## Fire Marshal Division

**Re: Donna's Country Kitchen**  
**174 N. McKinley St.**  
**Coats, NC 28334**

**Application Number BCOM1912-0008**

Amerex Pre-Engineered Fire Suppression System

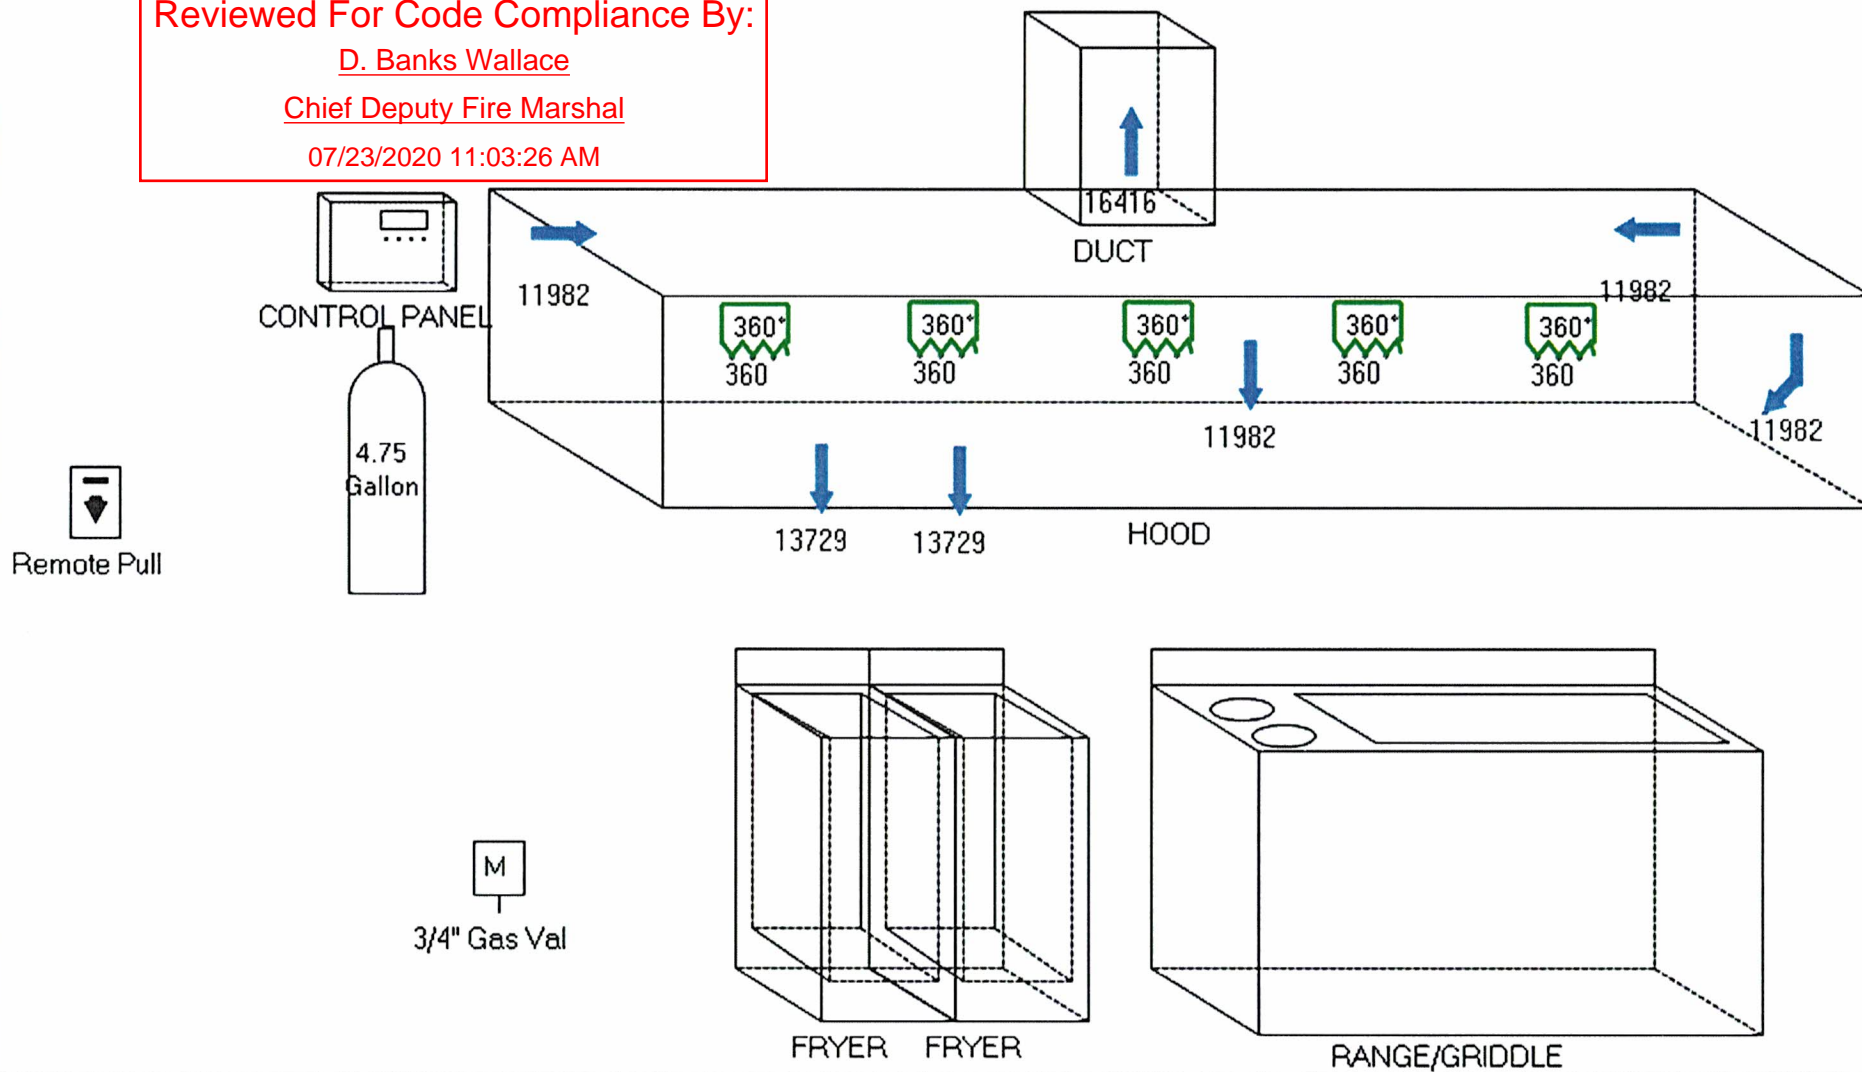
- **Commercial cooking equipment.**
  - Portable fire extinguishers shall be provided within a 30-foot (9144 mm) travel distance of commercial-type cooking equipment. Cooking equipment involving vegetable or animal oils and fats shall be protected by a Class K rated portable extinguisher.
- **Acceptance Test**
  - An acceptance test will be conducted by the Fire Marshal's office once system has been installed and pre-tested.
  - Installation shall be per architectural and system submittals and compliant with NFPA-17A.
- **Manual system operation**
  - A manual actuation device shall be located at or near a means of egress from the cooking area, a minimum of 10 feet (3048 mm) and a maximum of 20 feet (6096 mm) from the kitchen exhaust system. The manual

actuation device shall be located a minimum of 4.5 feet (1372 mm) and a maximum of 5 feet (1524 mm) above the floor. The manual actuation shall require a maximum force of 40 pounds (178 N) and a maximum movement of 14 inches (356 mm) to actuate the fire suppression system.

- The actuation of the fire suppression system shall automatically shut down the fuel or electrical power supply to equipment under the hood system. The fuel and electrical supply reset shall be manual.
